For and on behalf of
BAE Systems
Interested Party Reference No.
20053944

SUMMARY OF RELEVANT REPRESENTATIONS EXCEEDING 1,500 WORDS

BAE Systems, Warton Aerodrome, Mill Lane, Warton

- 1.1 This document provides a summary of BAE Systems' Relevant Representations on the Morgan and Morecambe Onshore Transmission Assets Development Consent Order in relation to potential impacts on Warton Aerodrome. The Relevant Representations provided details of the regulatory background within which Warton Aerodrome must operate.

Figure 5.6: Onshore biodiversity benefit and environmental mitigation areas

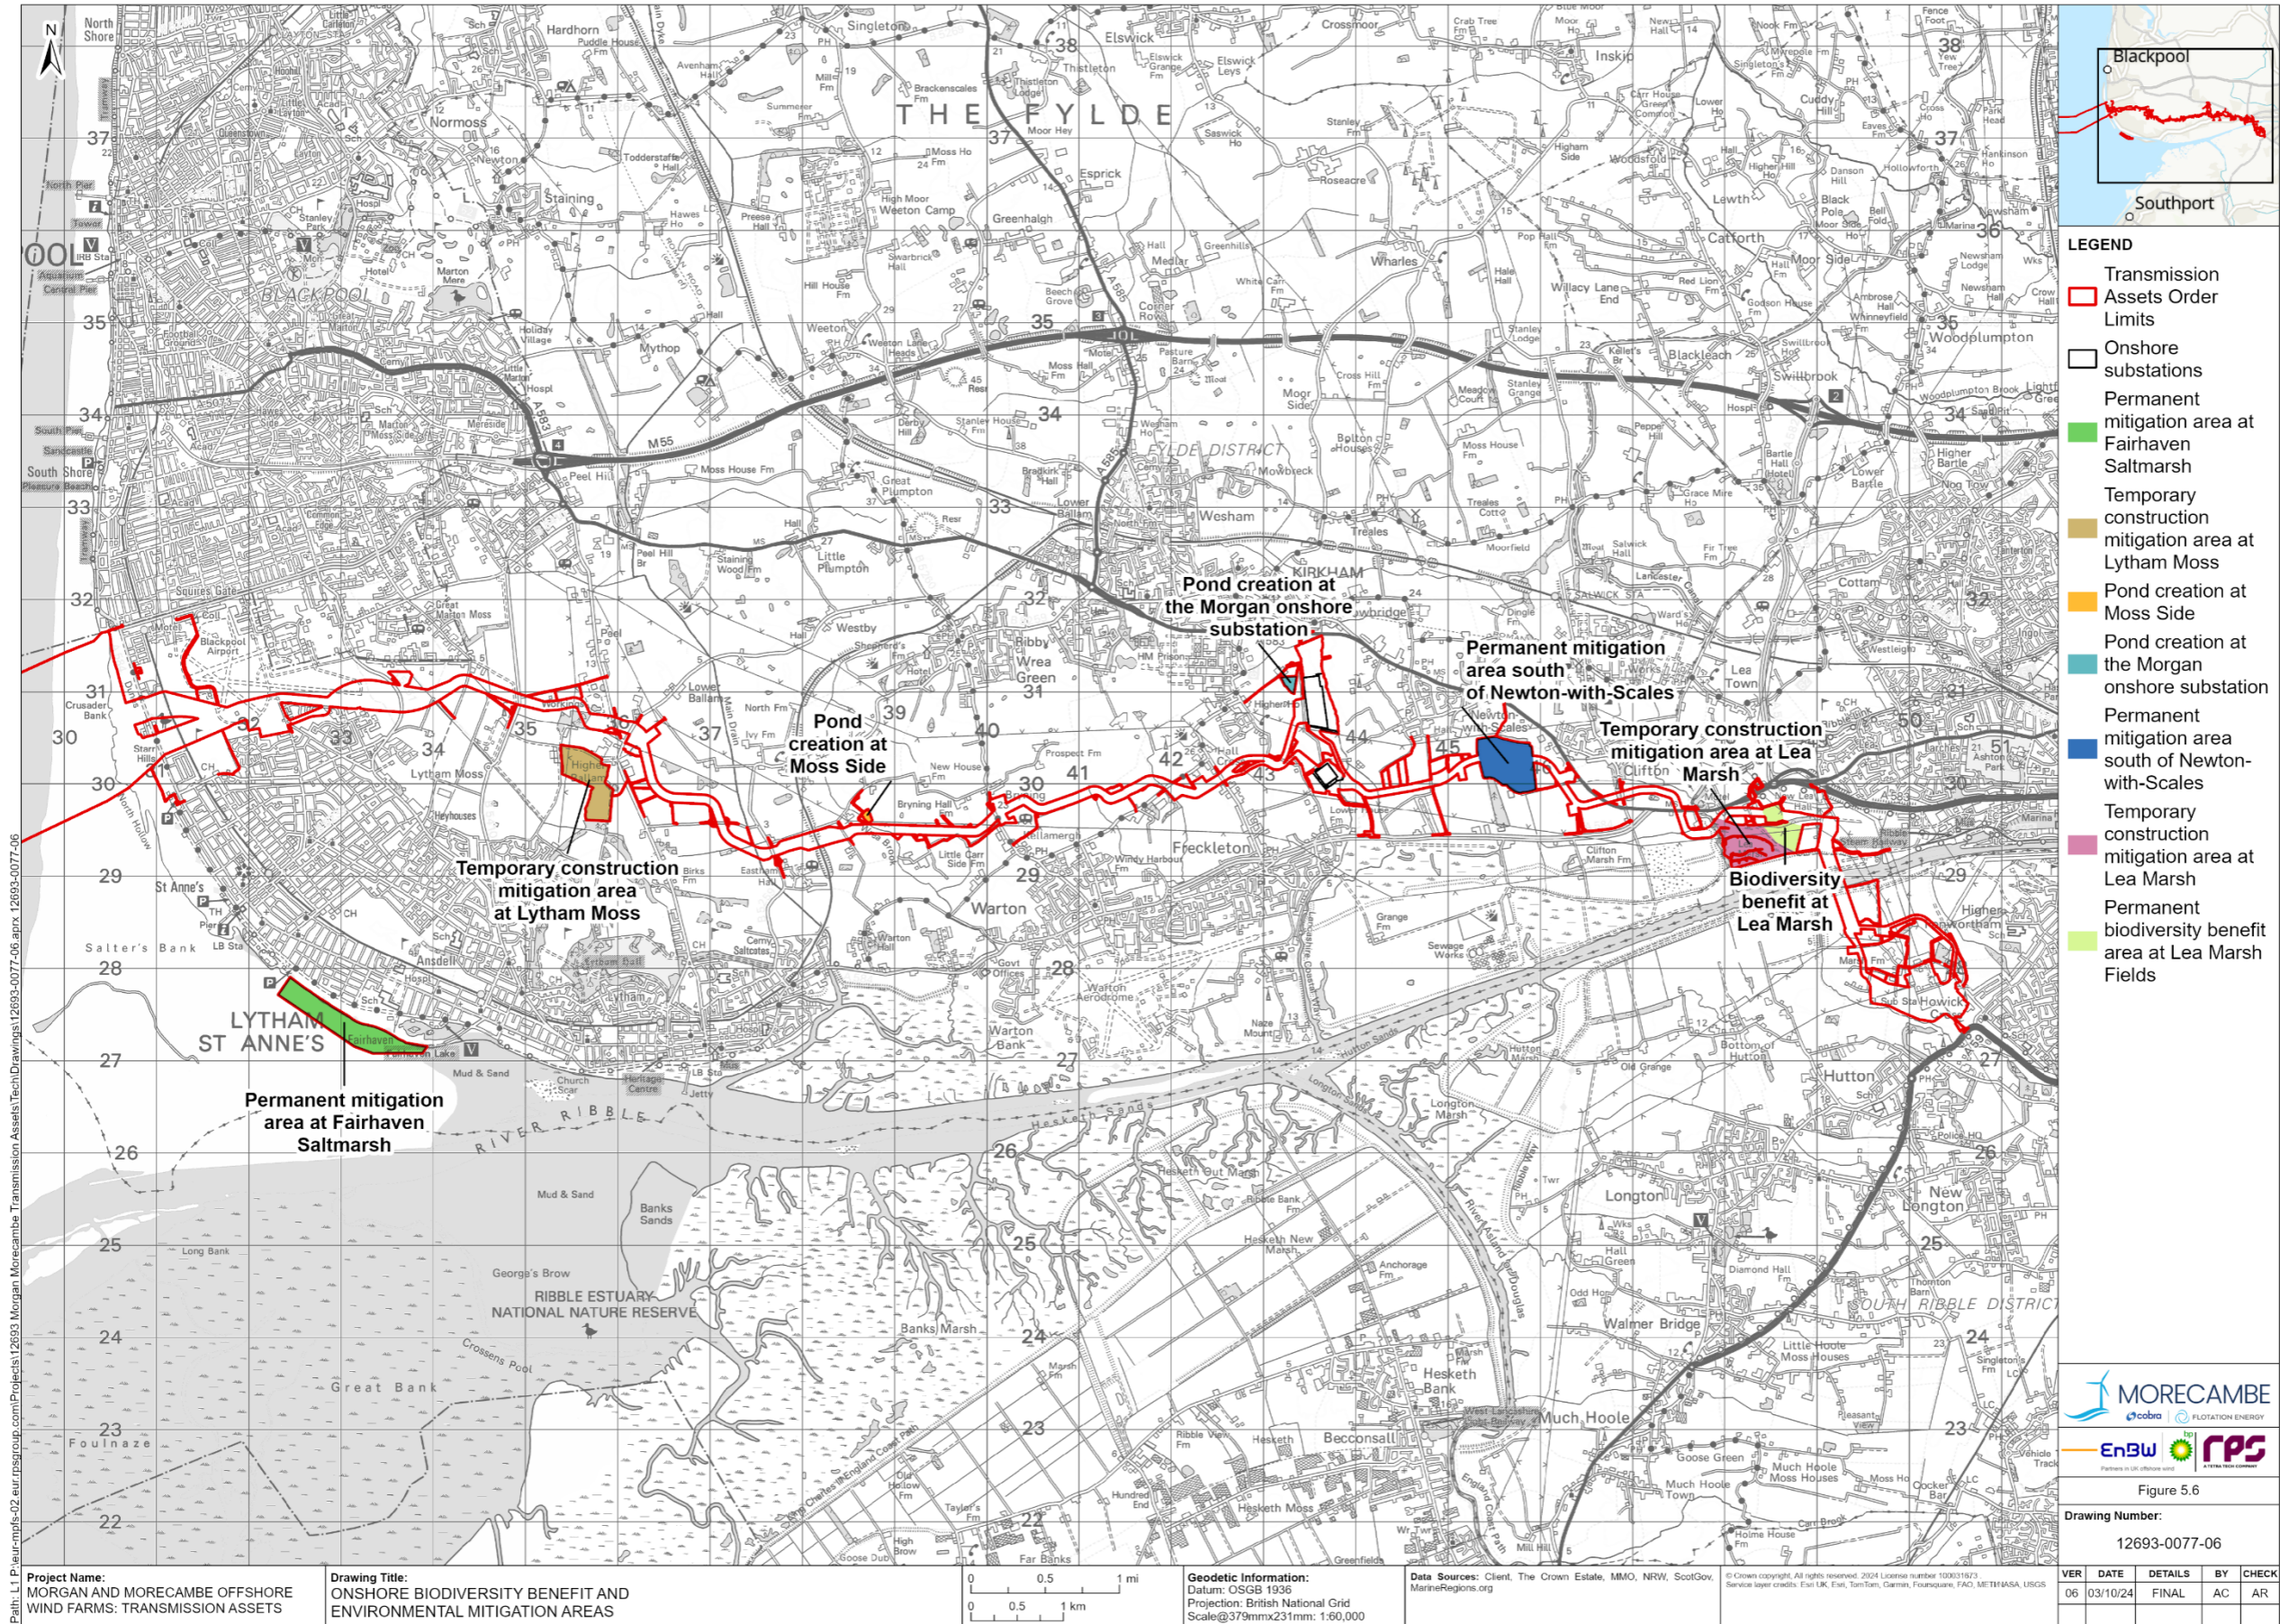
- The Biodiversity Benefit Sites are removed from the proposed development. They are not necessary to mitigate ecological impacts, and any benefits to biodiversity are significantly outweighed by the risk to life that they could pose through increased bird strike risk.

- During the Examination, the Applicants engage with BAE Systems to discuss the potential implications of the habitat to be created at the Mitigation Areas on safe flight operations in and around the Aerodrome resulting from increased bird strike risk. These discussions should identify measures to reduce / minimise increases in bird population in the area as a result of the habitat to be created / enhanced at the Mitigation Areas, such as the design of habitats to minimise bird attraction and / or management measures.
